**Consultation Response from KC,
Highways Development Management**

2023/92278 507A, Bradford Road, Batley, WF17 8LL

Formation of two additional floors and creation of six trade counter units within existing building and external alterations to existing brick clad portal framed industrial unit (within a Conservation Area)

Date Responded: 13-12-2023.

Ground Floor Plan 1: 100

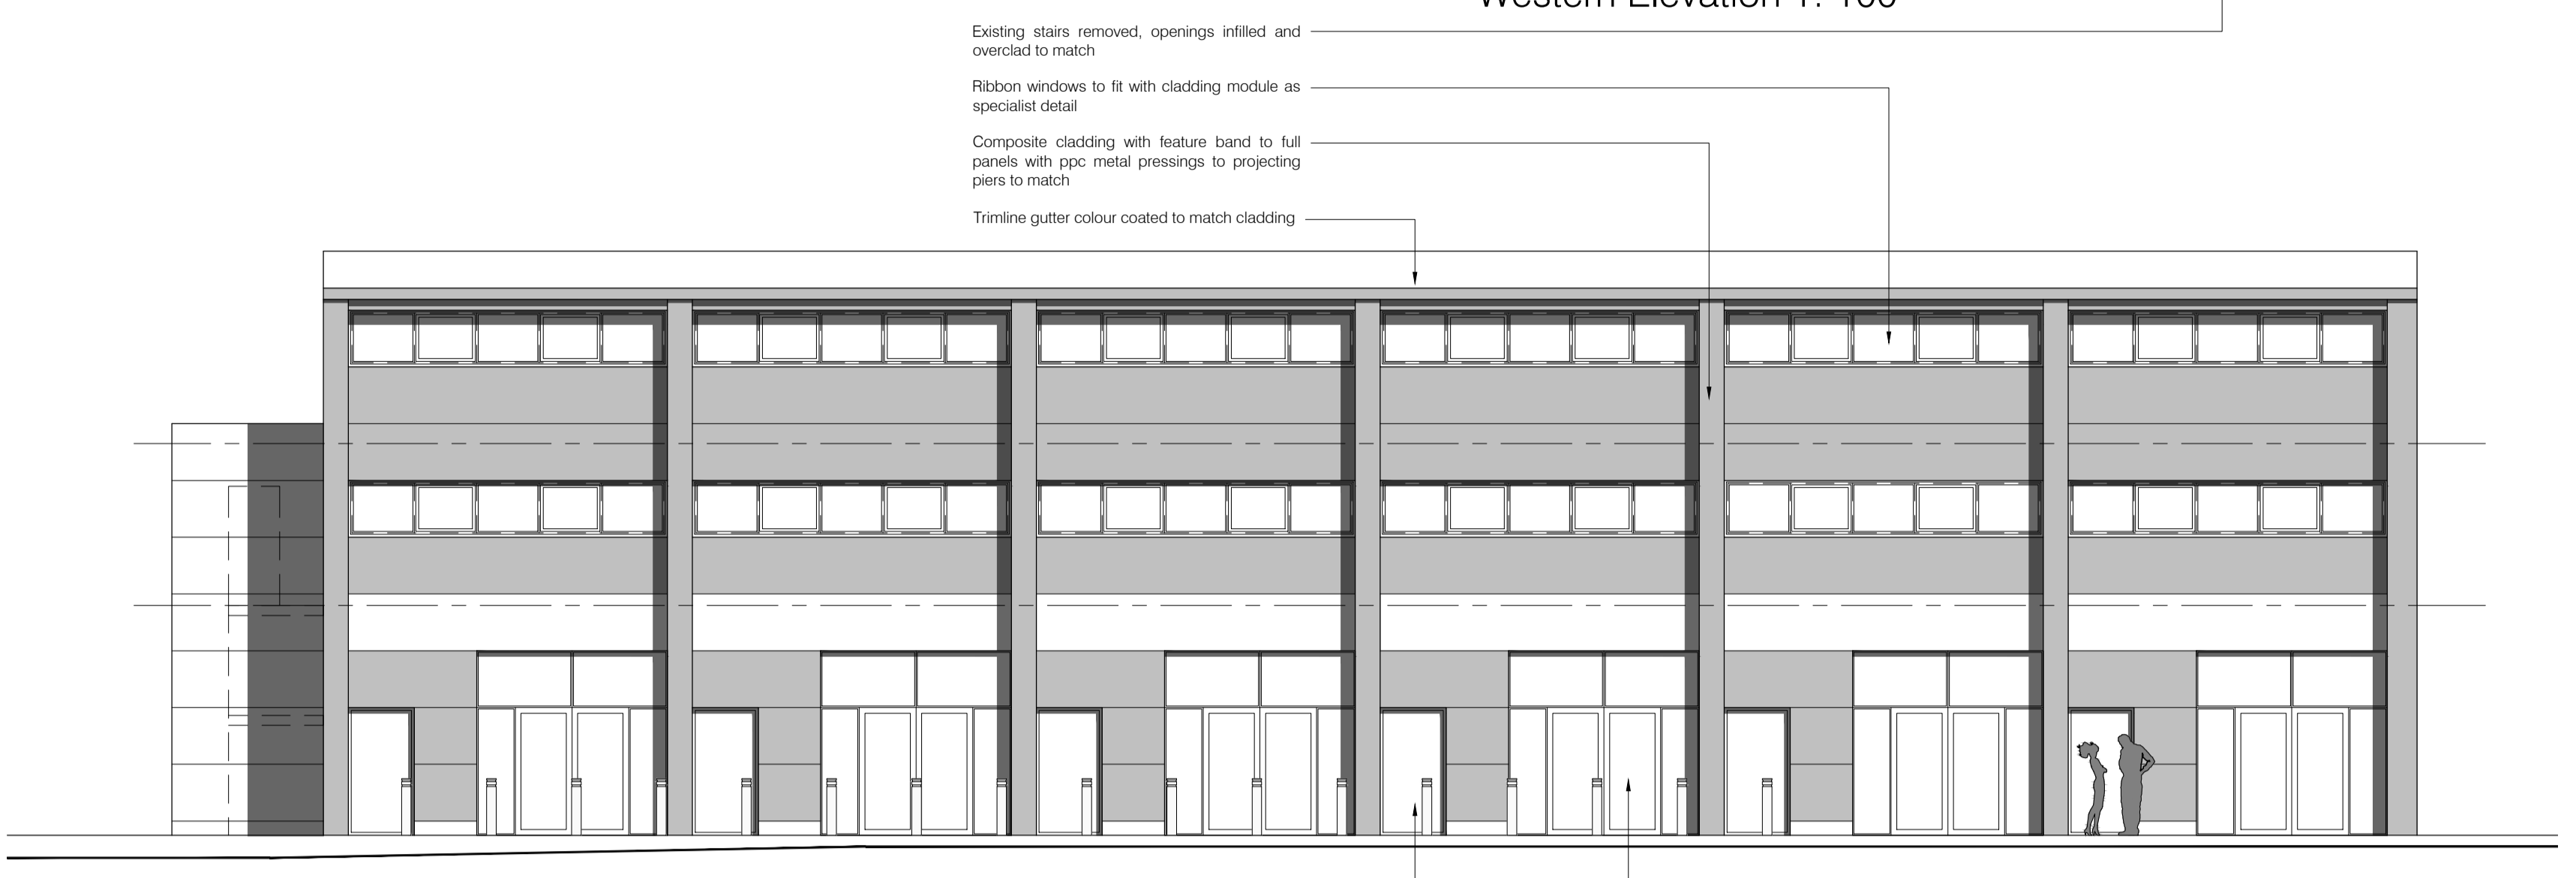
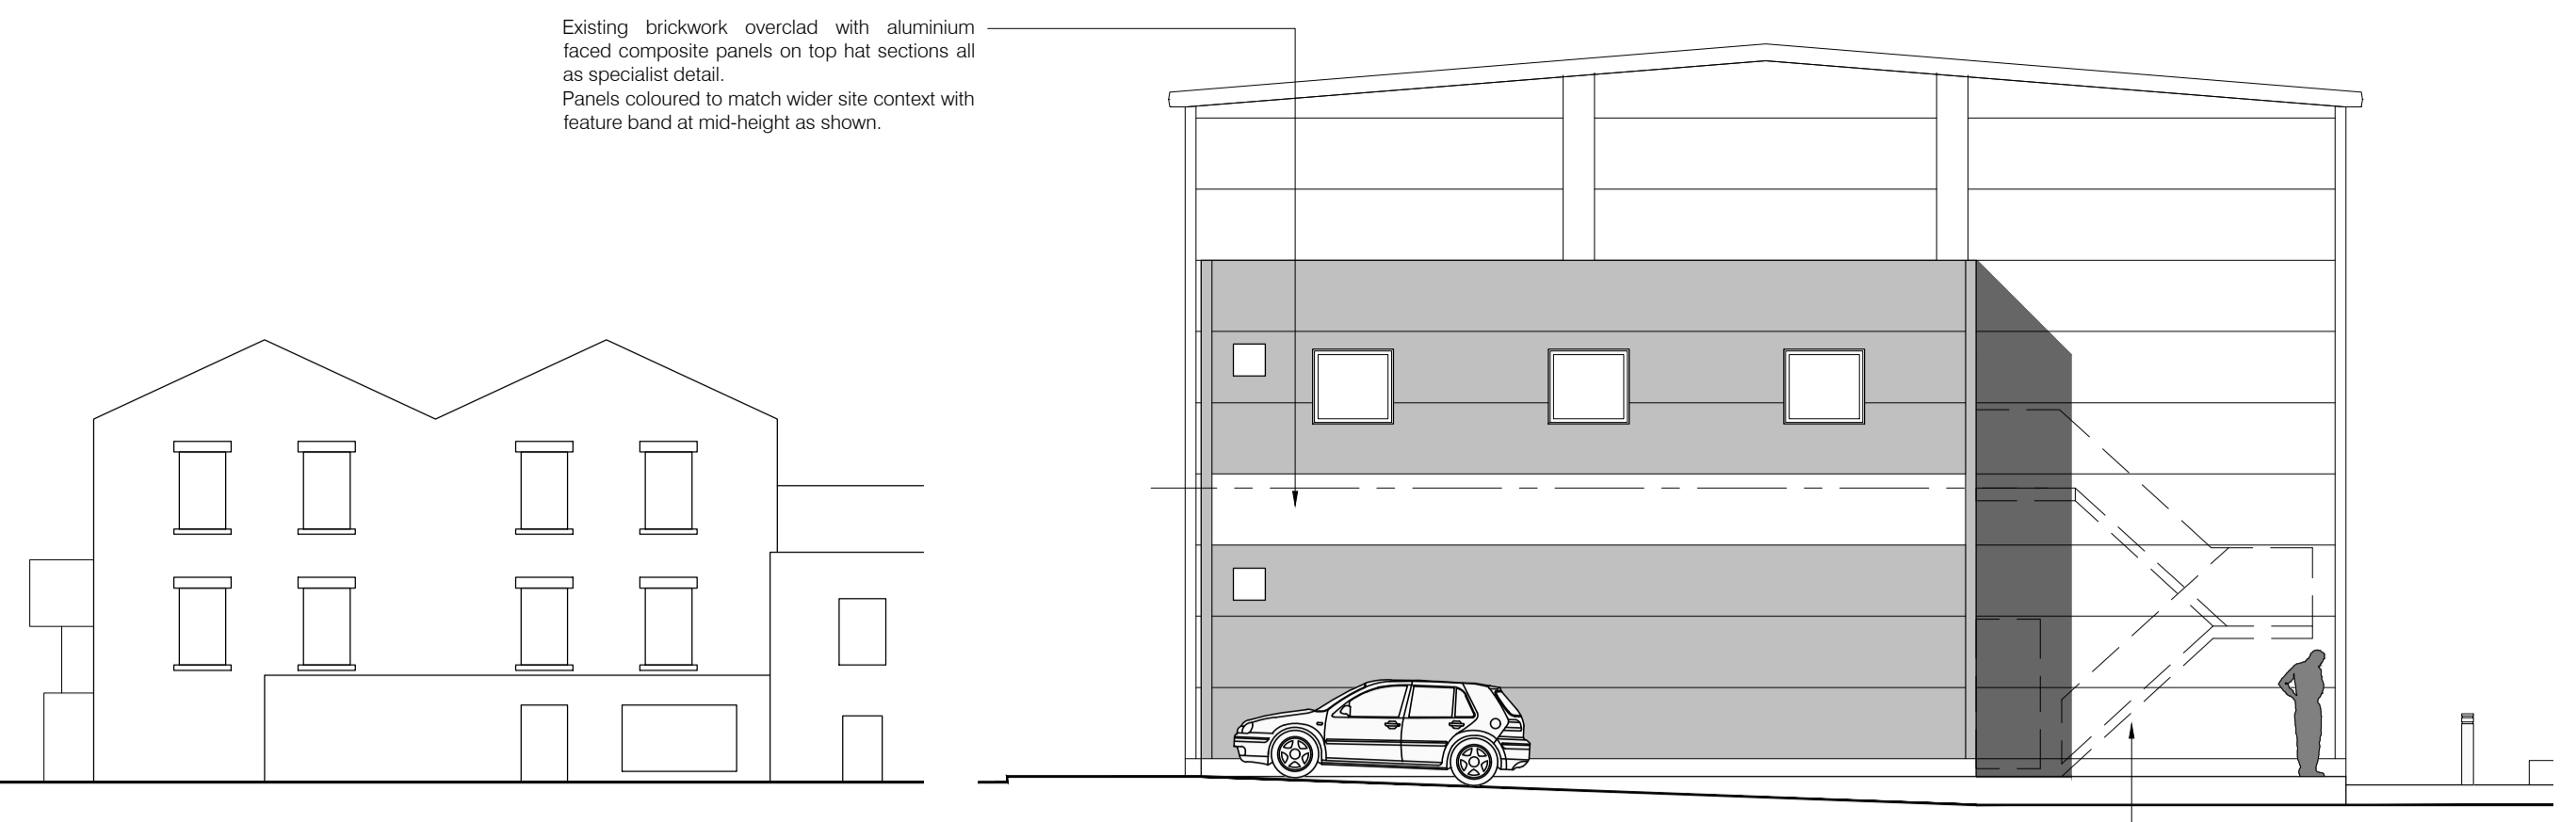
These proposals show display areas with an access onto Bradford Road. Can the applicants be asked to explain how the display areas will operate. Will there be access from Bradford Road for sales or is this area simply for the display of goods.

Block Plan 1: 200

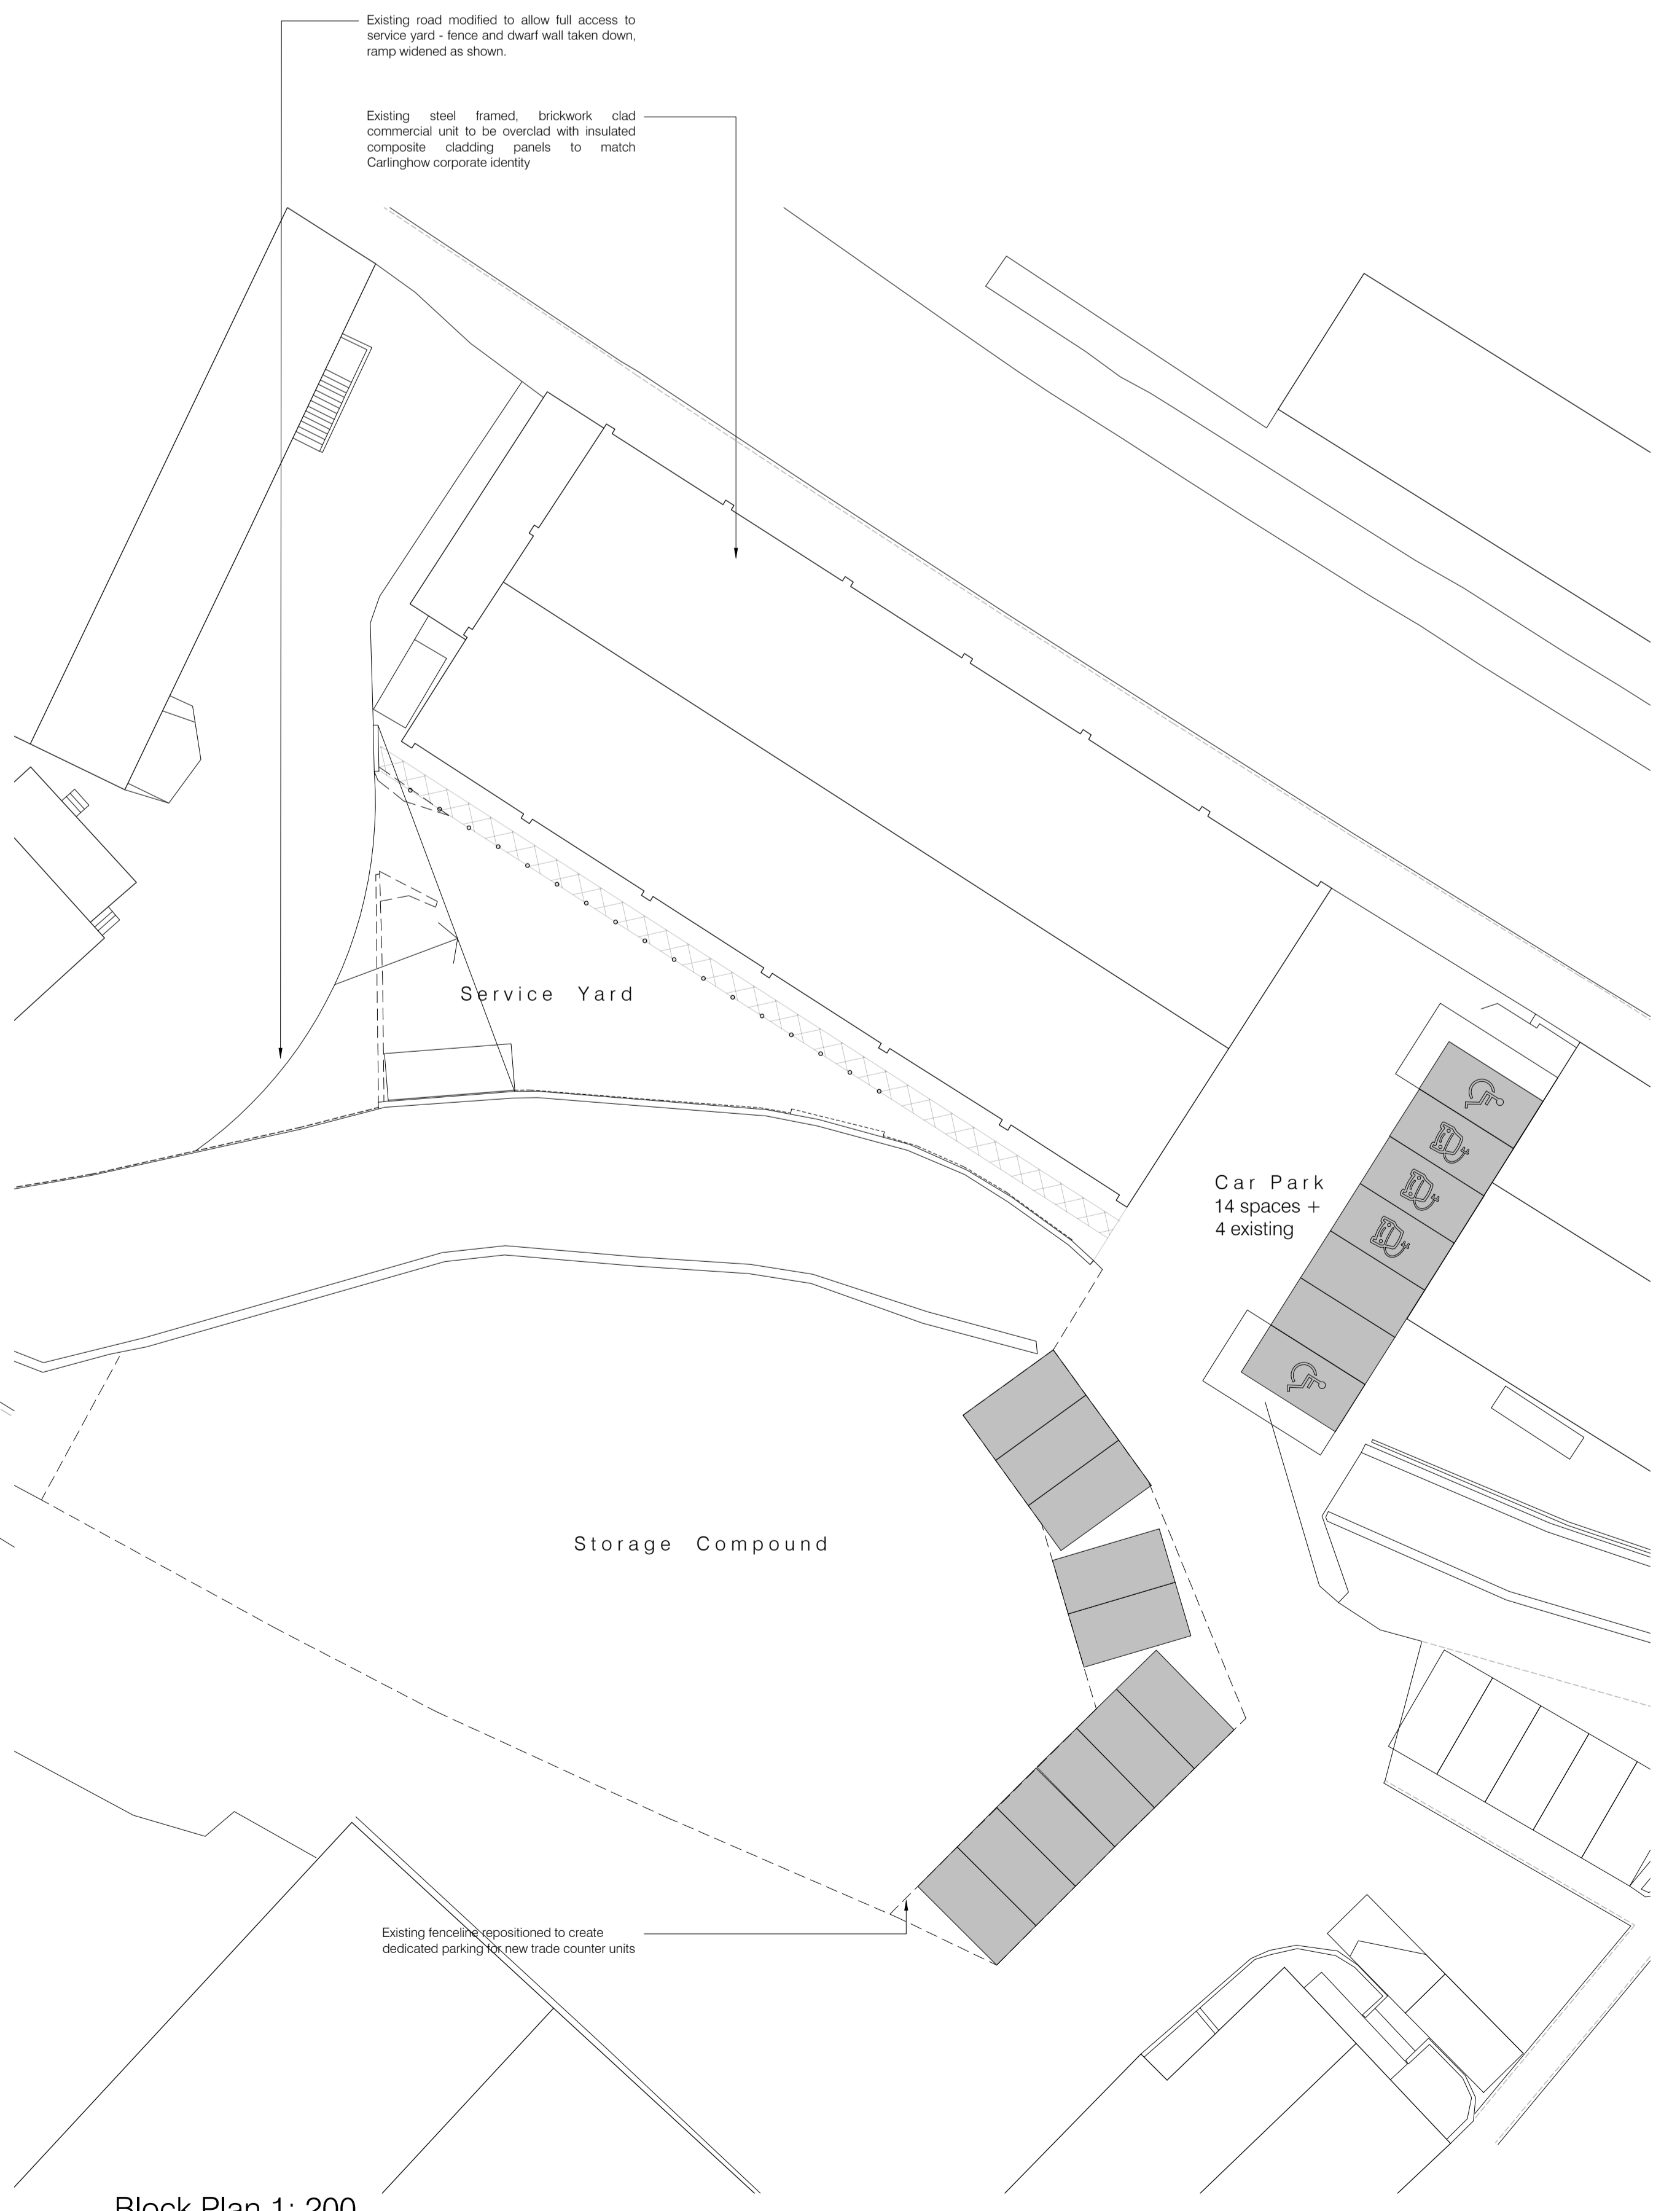
The proposed parking areas are shown within the Carlinghow Mills development and to the eastern side of the building. Access to the proposed parking is via the eastern access and servicing is via the western access. Swept paths are provided to demonstrate that a refuse vehicle can turn within the site.
